13th July, 2018

AW71/18/HH – 36 Kingsway – Conservation Area - Objection

Tree survey

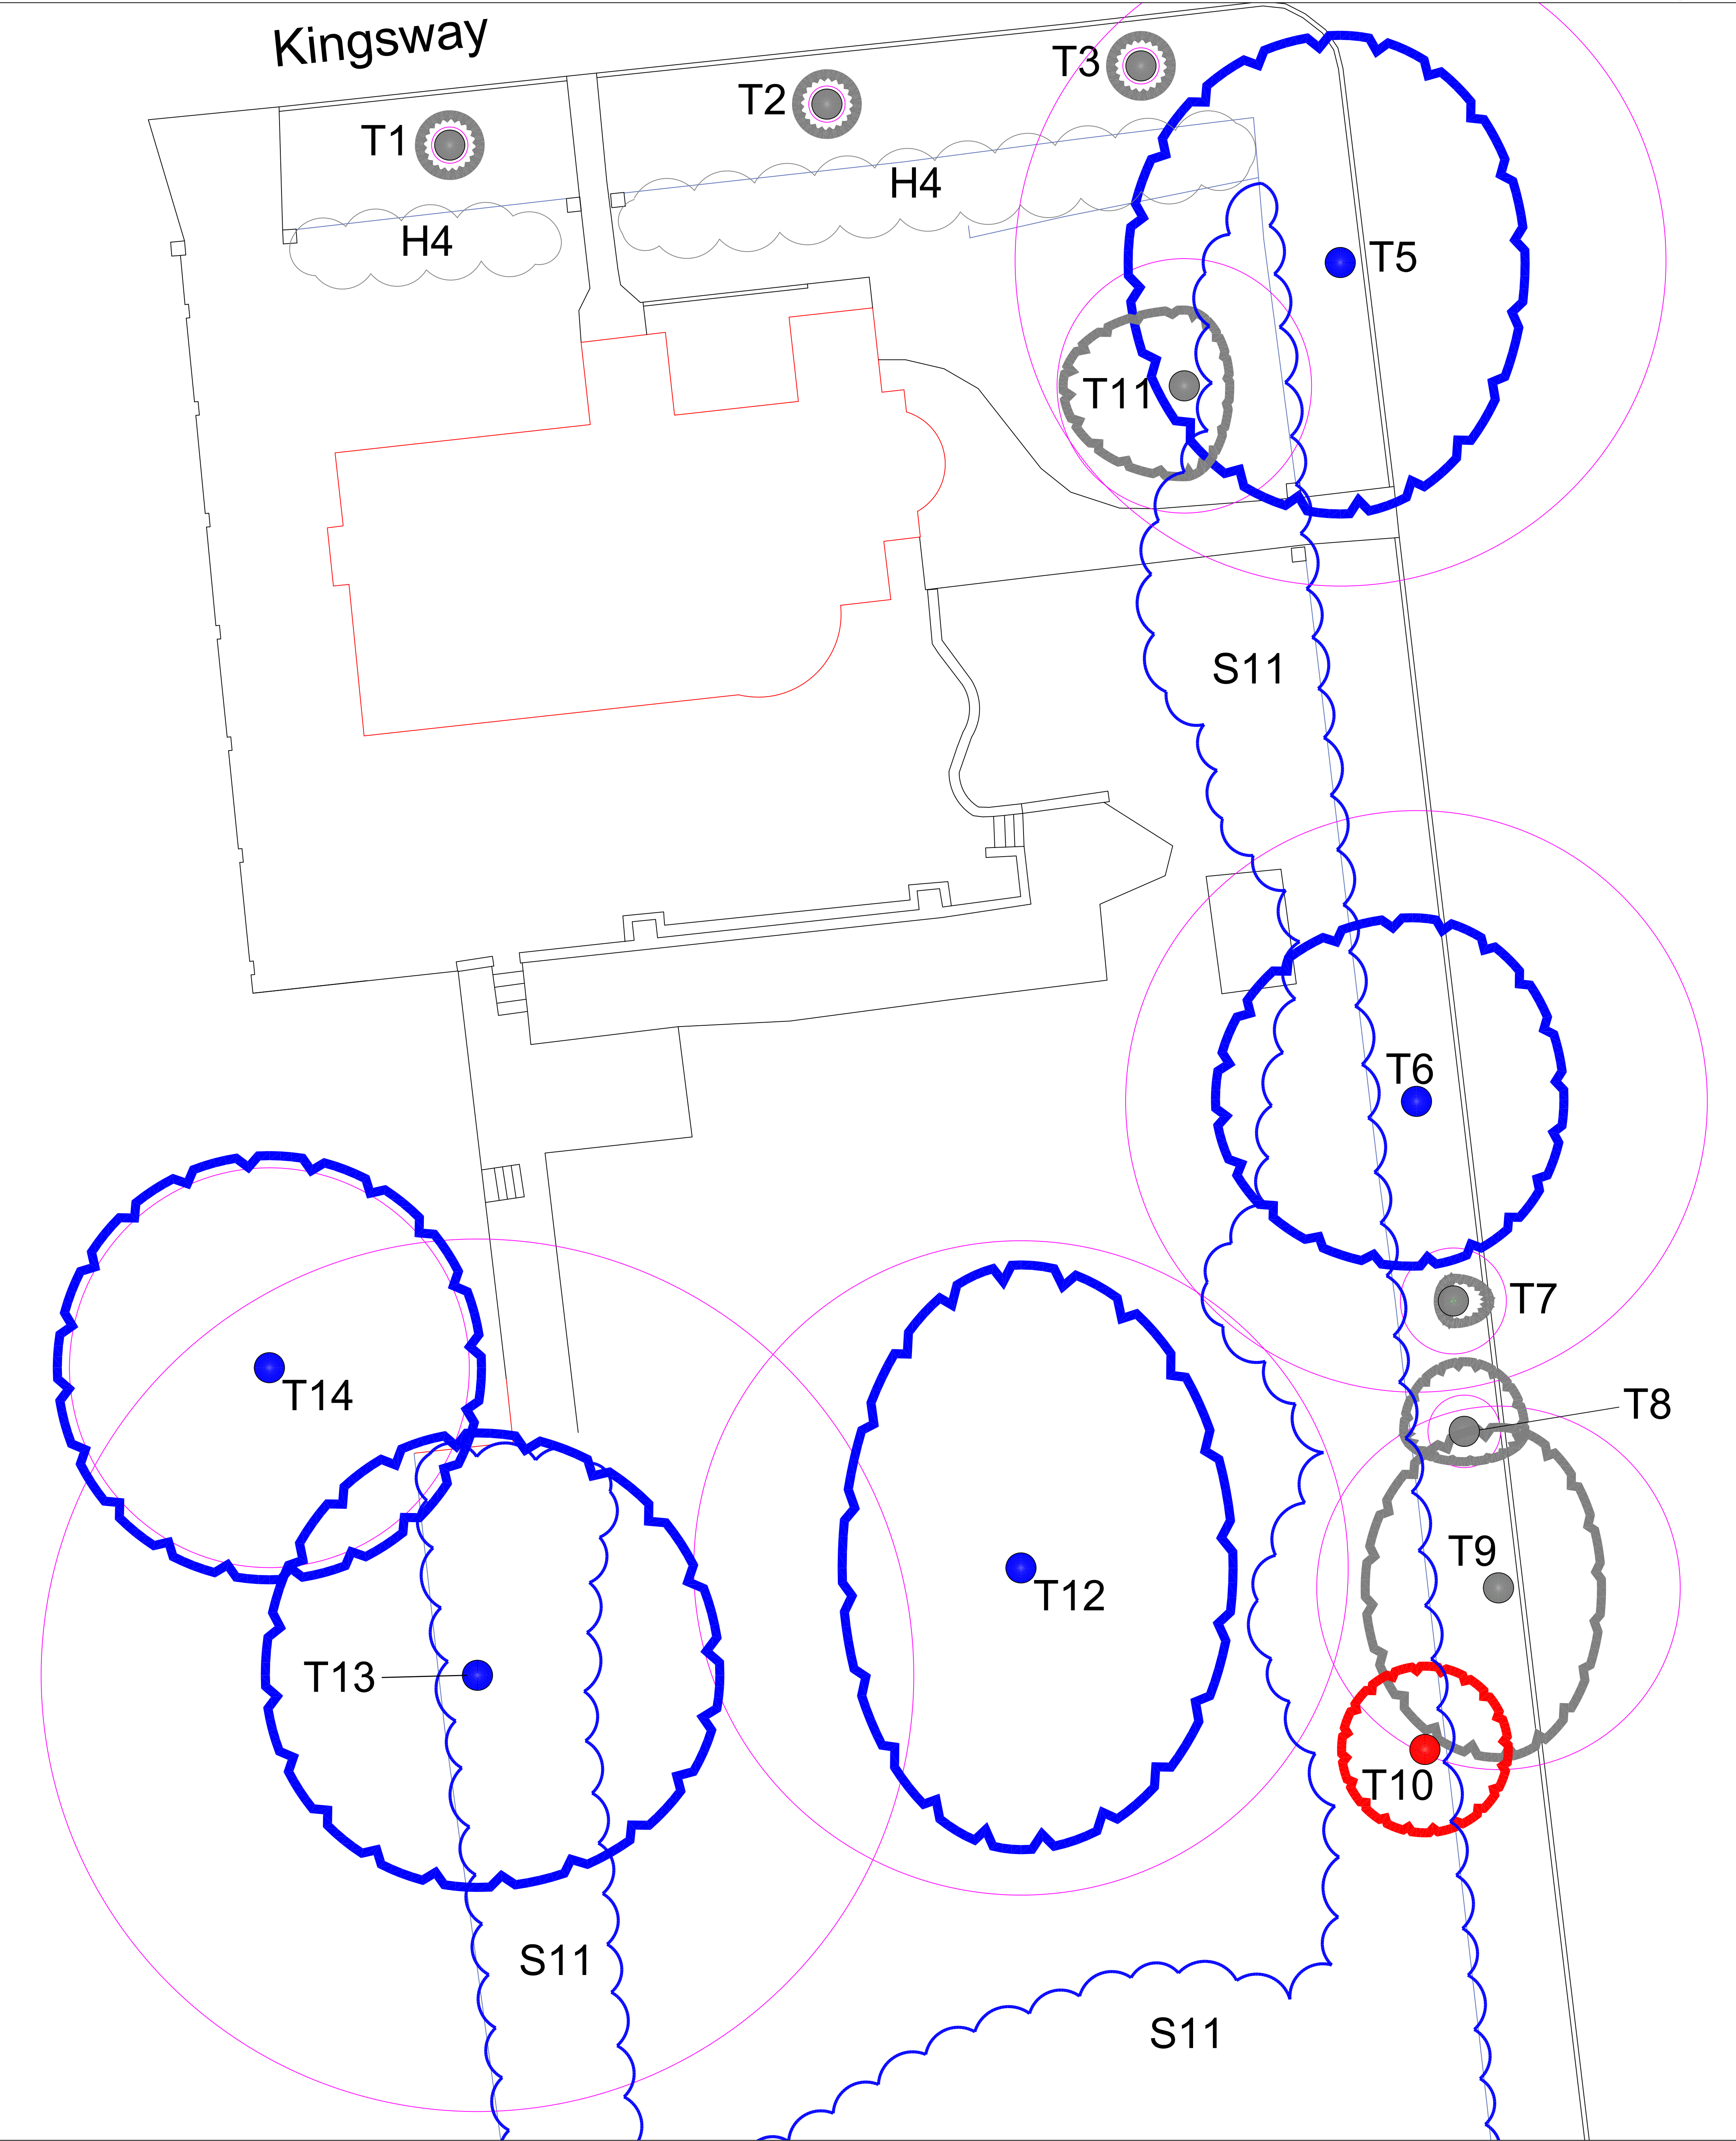
This line of trees has now been downgraded to 'a relatively poor quality hedge' flatly contradicting the attached July 2018 Tree Survey Schedule which classifies these trees as being in good physiological/structural condition with an estimated 10 years of contribution and no immediate management requirement.

The Tree survey of July 2018, under 8.3, claims that 'The area between the drive and the tree T5' will be retained as soft landscape', ignoring the fact that this small area, bounded by T3, T5 & T11, already has significant trees growing in it, none of which are shown in any drawing that I have seen. We have had tree assessments in 2016, subsequently revised in March and July, 2018 and no-one has noticed these trees, one of which must have a DBH of at least 120mm and a height of 7m. There are too many

TITLE
**Cellweb Section - Tree Root Protection
c/w Block Paving Surface**

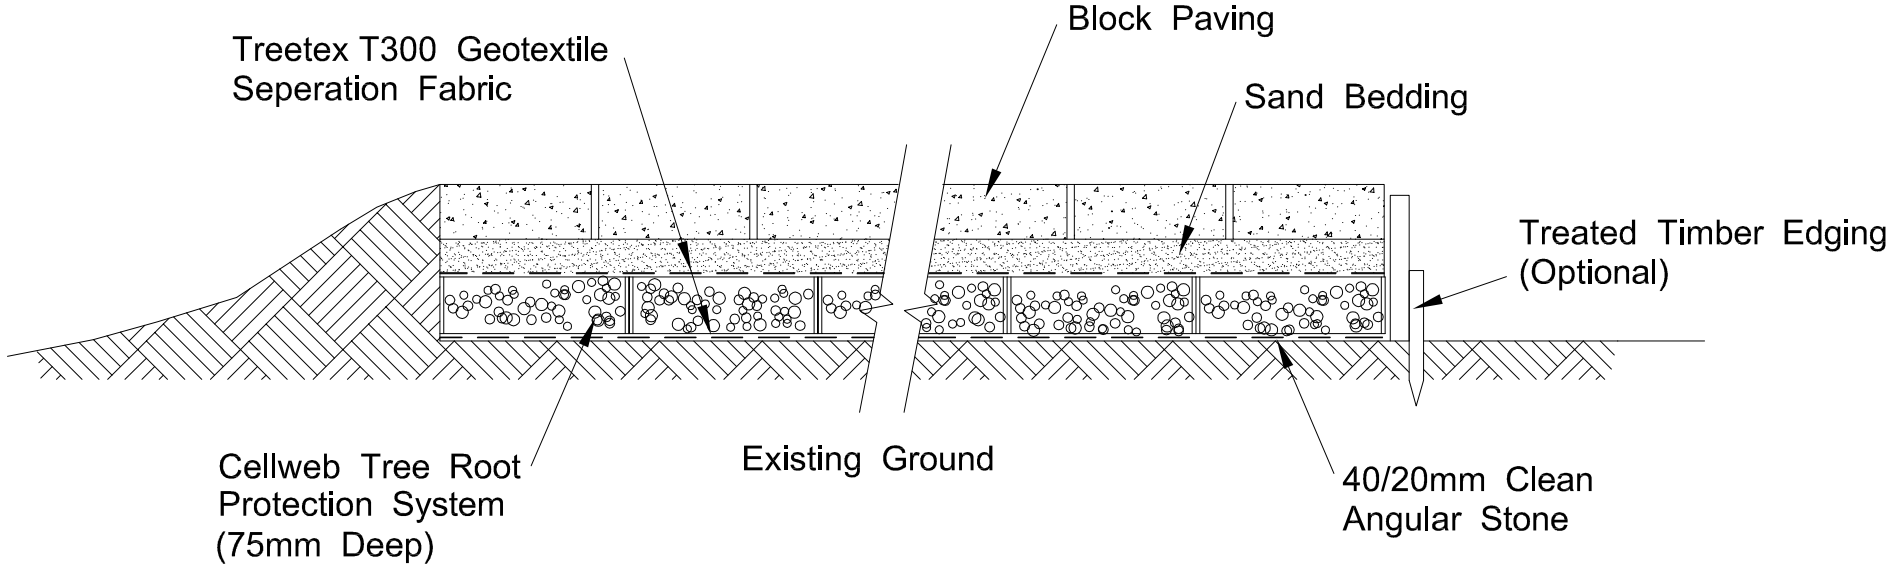
The revised 'existing section C0019-P207' describes the grass verge as a pavement and shows it sloping up from road level. To my eye the current grass is actually level, but the new crossover would indeed involve a rising ramp across the grass verge to accommodate the Cellweb section. This would certainly detract from the street scene. In that same drawing the hedge height is given as 3m, completely at odds with the 2016 Tree Survey height of 5m, which is probably now nearer 7m.
